Current Zoning: R-3 (single family residential)  
Proposed Zoning: R-8MF(CD) (multi-family residential, conditional)

Approximately 48.09 acres located south of North Tryon Street, east of Trevi Village Boulevard, and north of University City Boulevard.

The petition proposes to allow a residential community with 285 townhomes on a parcel of vacant land, located south of North Tryon Street and bordered by Cabarrus County to the east.

## PLANNING STAFF REVIEW

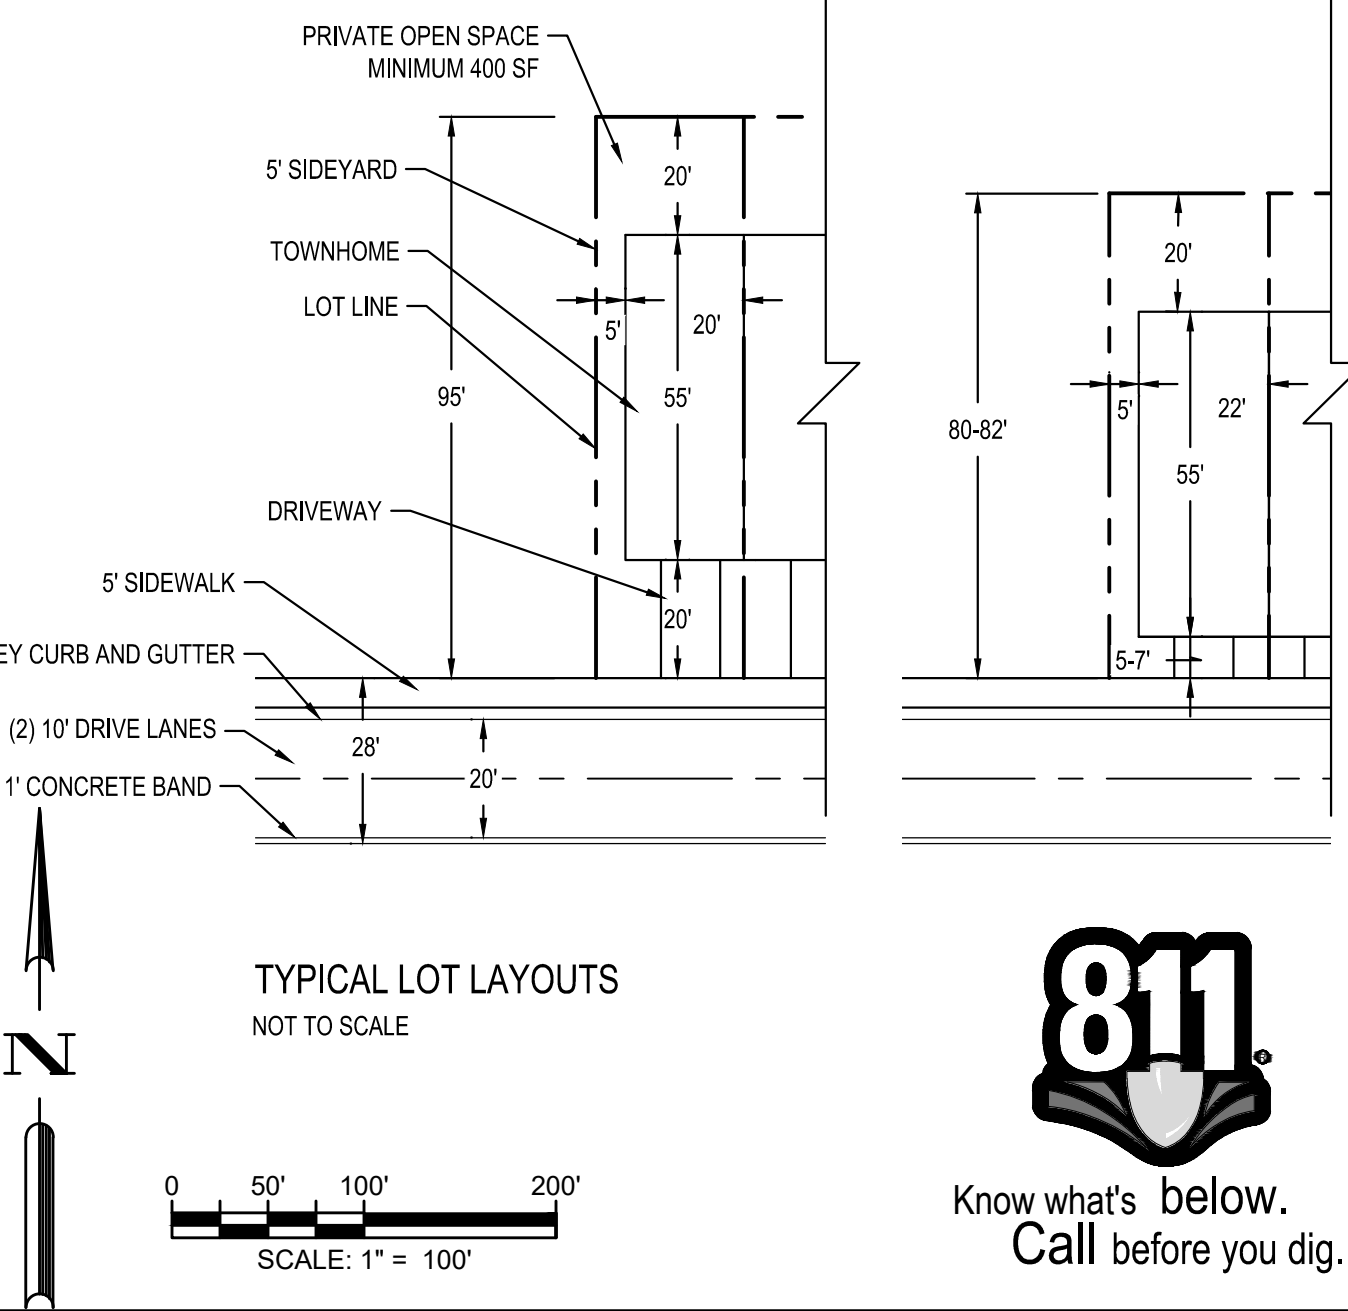
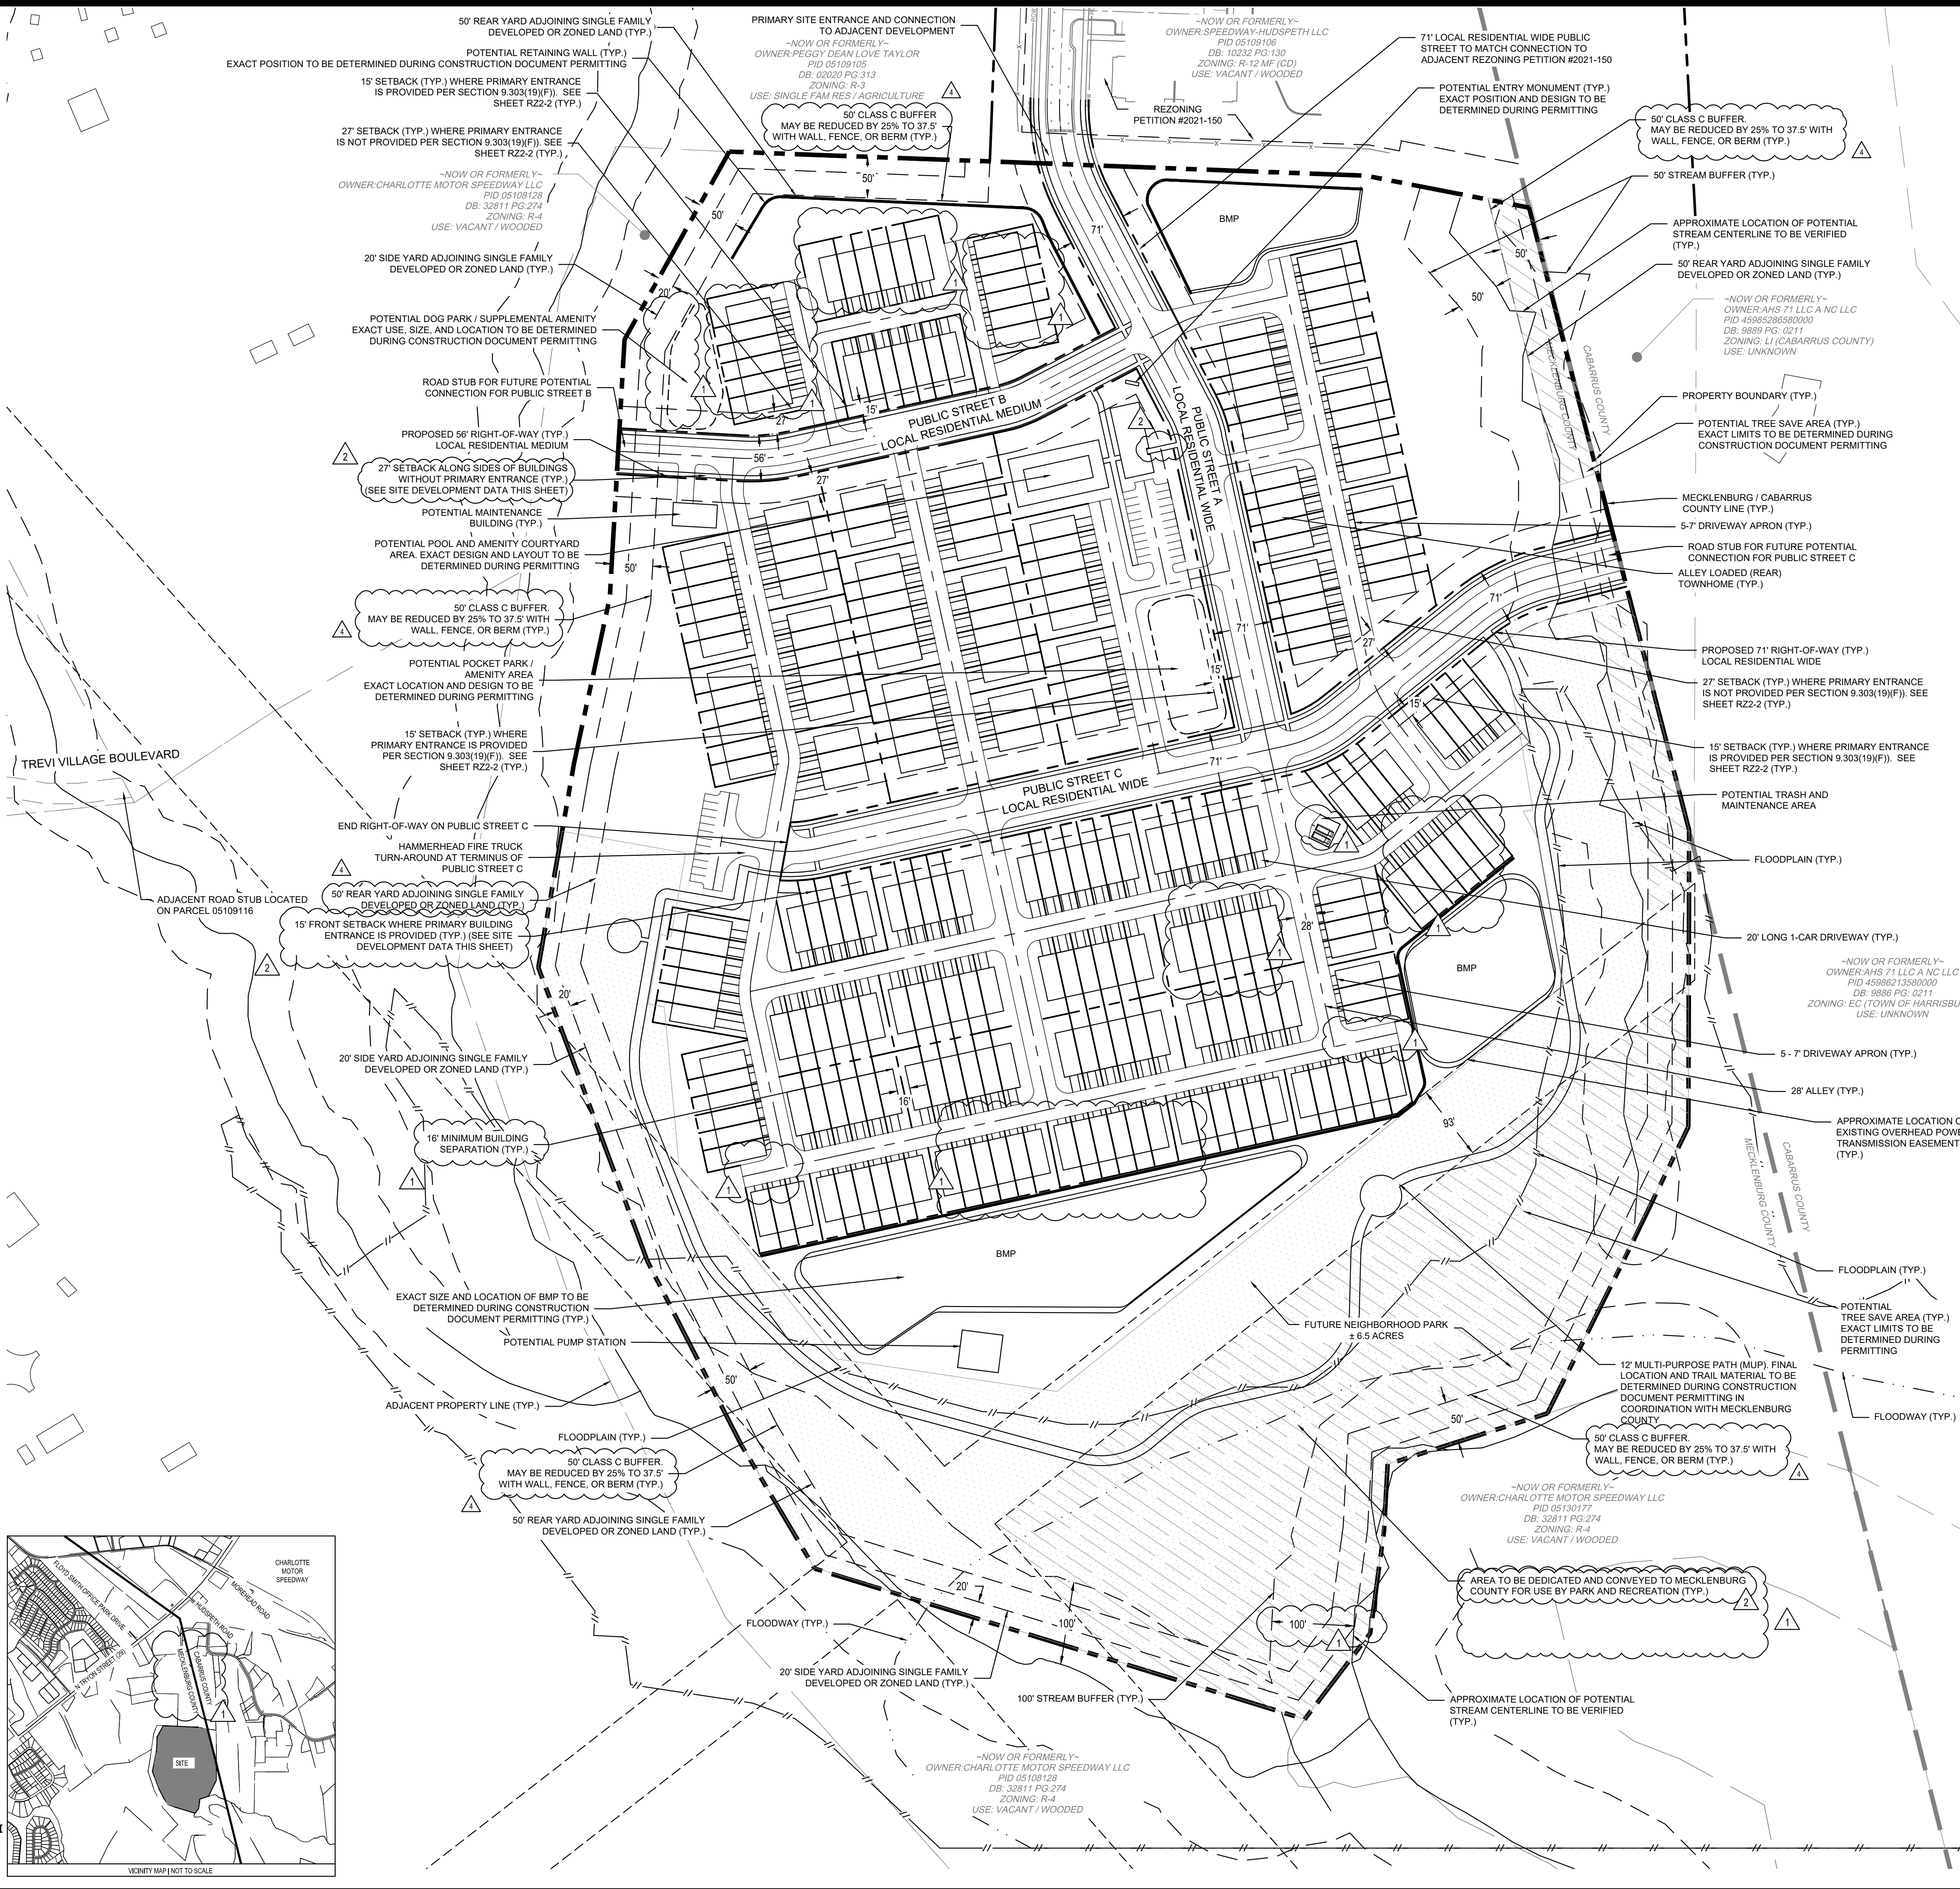
- ~~2. Amend labeling on Class C buffers illustrated on plan to state they may be reduced 25% with wall, fence or berm, not buffer, berm, or fence.~~ **Addressed**
